2nd August 2023

RE: The Britannia Inn, London Road, Headington, Oxford, OX3 7AA

Further to our original report dated April 2023 we revisited on Monday 31st July 2023 to meet with Pinetree and check the areas they have currently rectified and review other areas identified.

Ground Floor Plan
Showing Over Strengthening
(1:50)

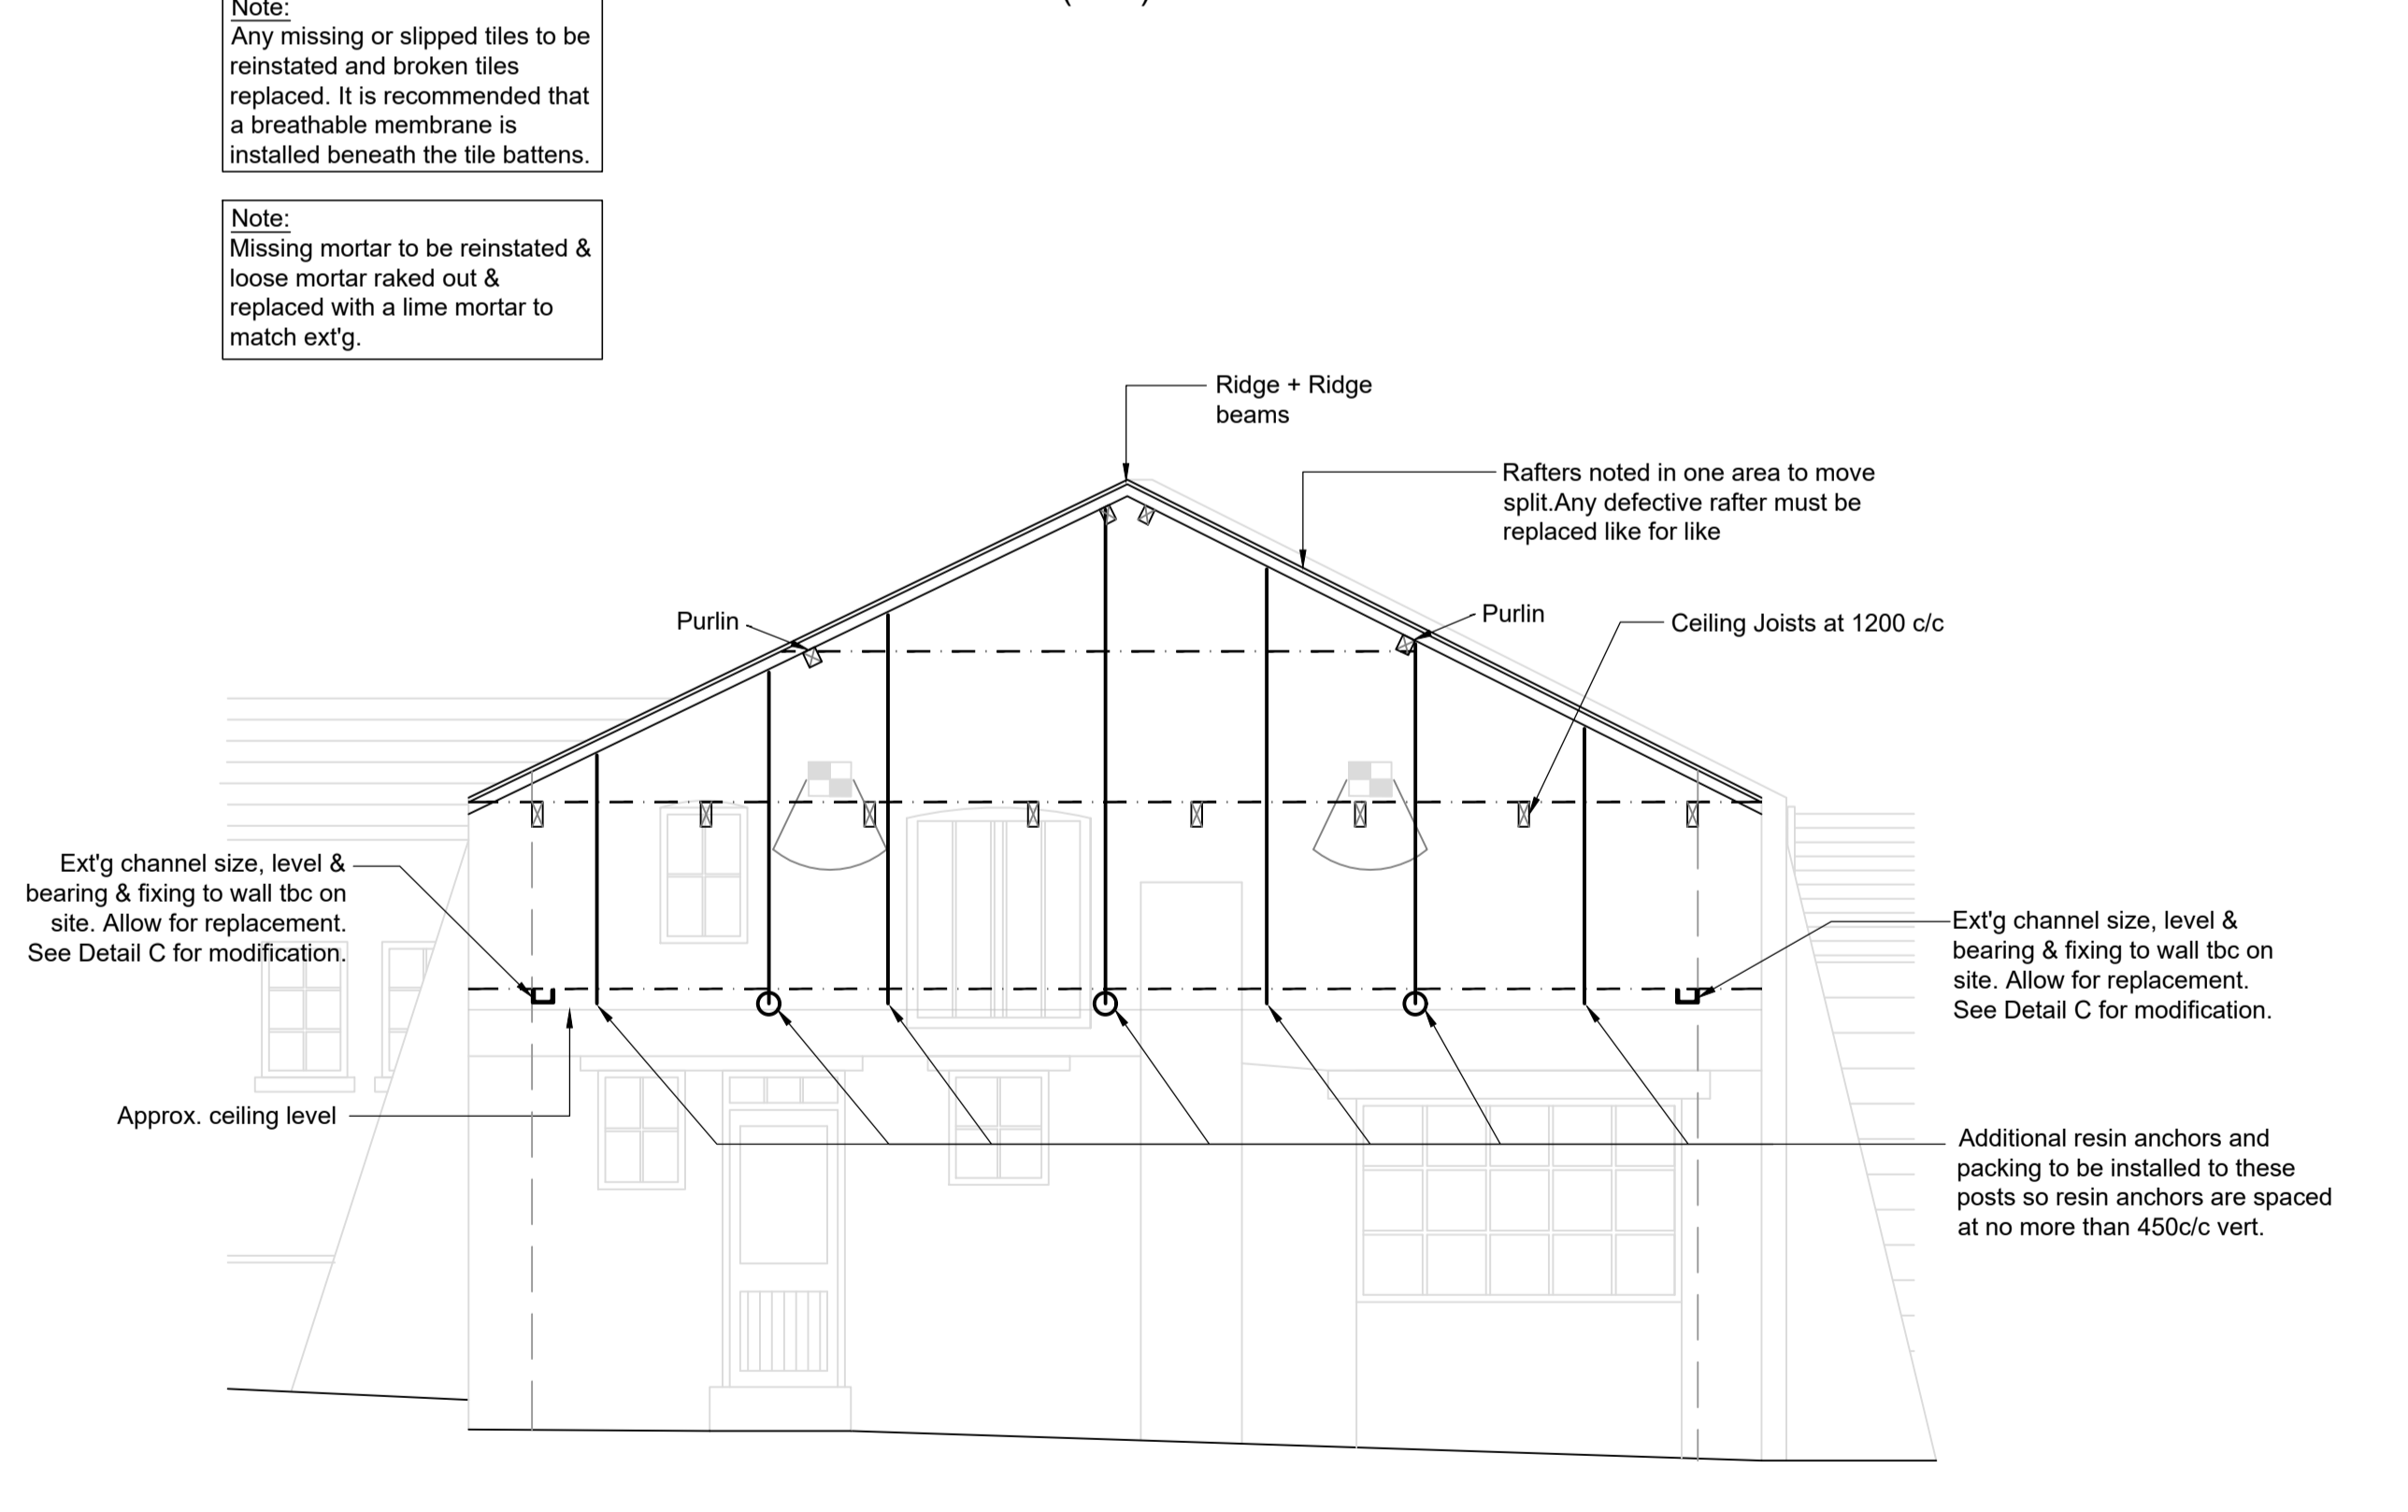
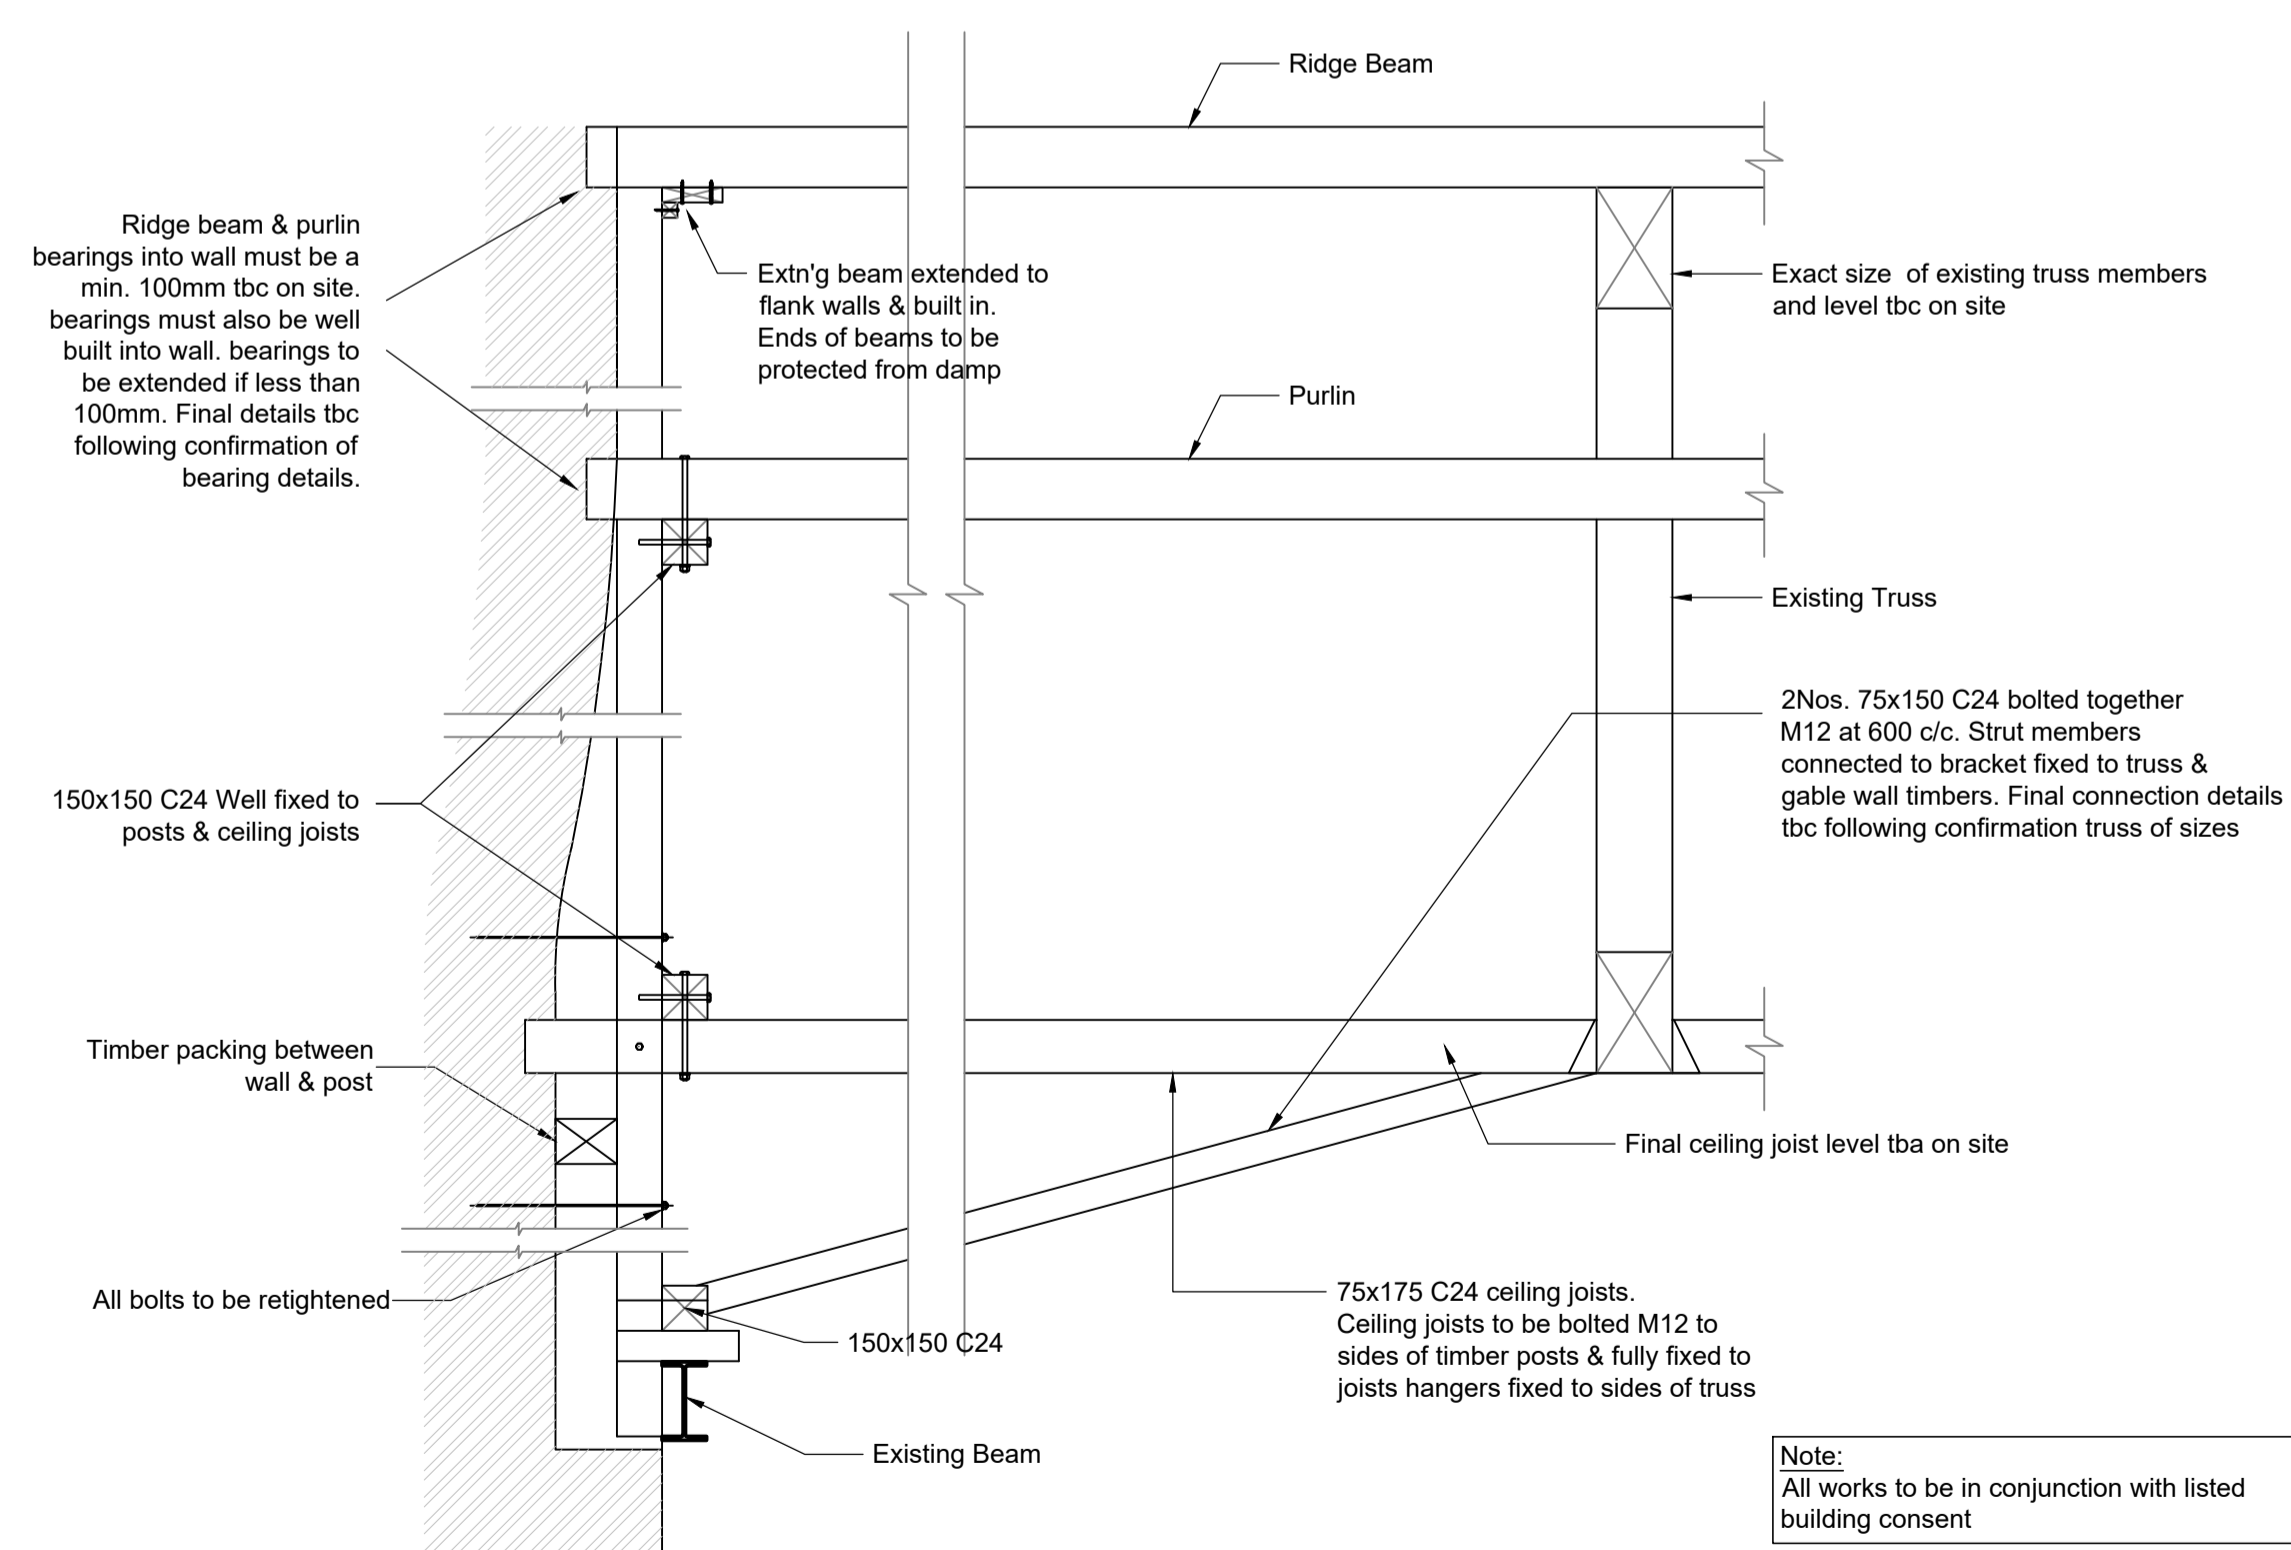
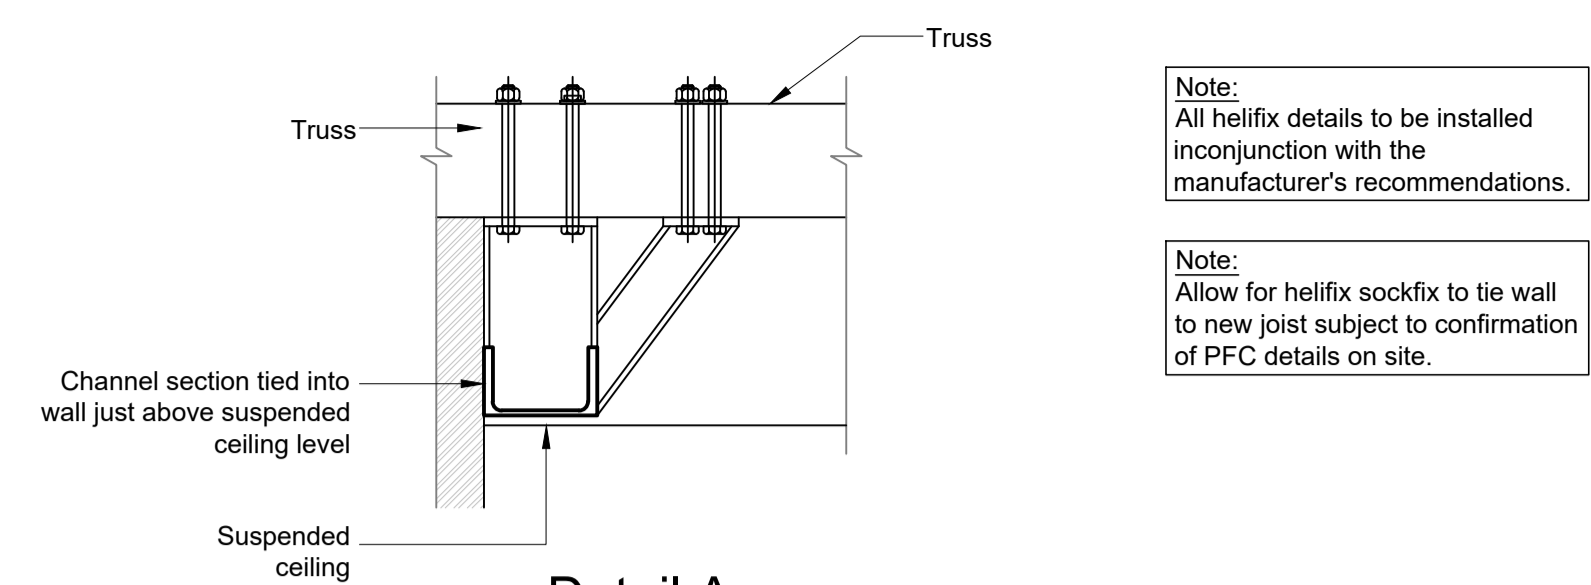
- Inspection of the roof structure over the dining area where there were damp issues identified radiator pipes that could have been leaking. This should be addressed.
- The main roof tiling over this area was generally sound but there were a number of gaps and missing tiles that would allow water in. these should be addresses.
- The gable wall in the lower restaurant seating area above the suspended ceiling is currently restraint by some timber posts. This we do not feel is adequate and requires strengthening.

It is highly probable that continued movement of the upper section of gable had resulted in the separation with the external brick pier. It is also felt that the existing floor that would have been over the suspended ceiling that has been removed will have been a major factor in the bowing of the walls.
